**Arrowhead Trailer Rural Home Occupational Expansion, AL-23-29**

Please accept the following comments from El Paso County Public Health regarding the project referenced above:

PROPOSED SITE PLAN
13925 E US HIGHWAY 24 PEYTON, CO 80831
PARCEL #: 4233001001
AREA: 1,140,836.00 sqft (26.19 acres)

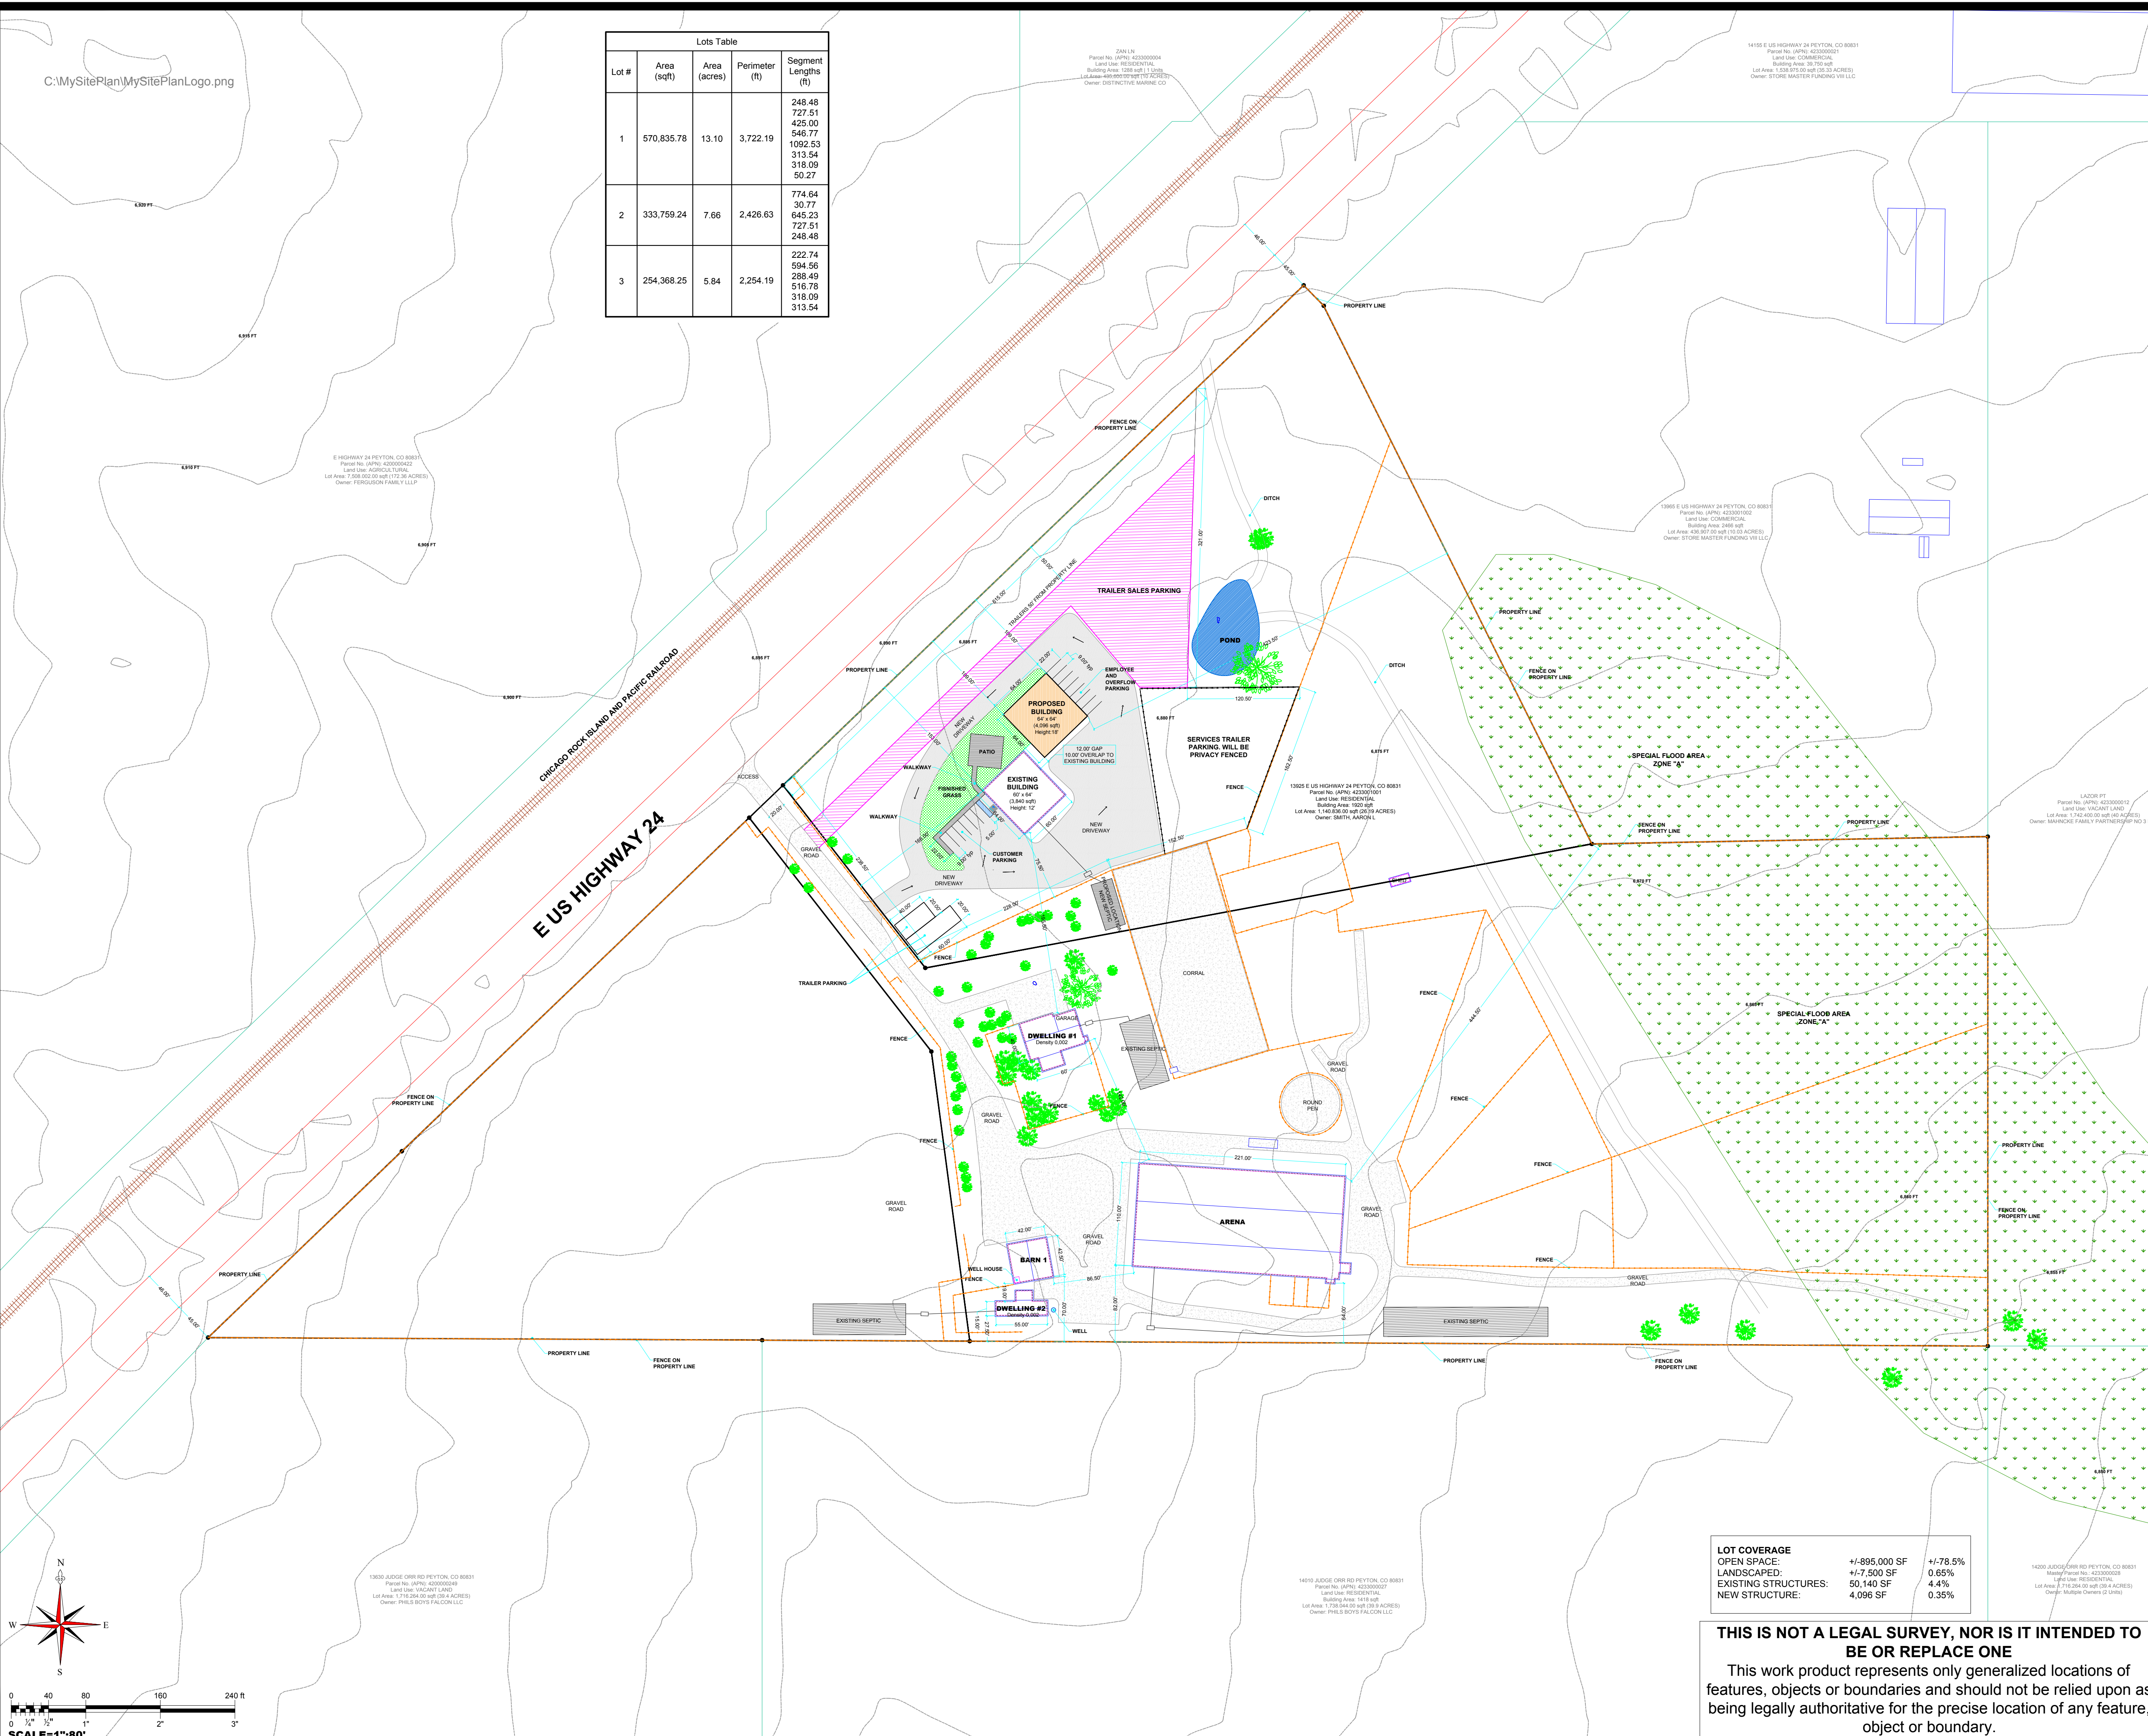
- Water is provided by an individual private well. Wastewater is provided by an onsite wastewater treatment system (OWTS).
- A bathroom is proposed for the horse barn which is being converted into a parts/sales room. The bathroom must be connected to a permitted and approved OWTS and comply with the El Paso County Public Health OWTS Regulations.
- No other Public Health issues noted with the request.
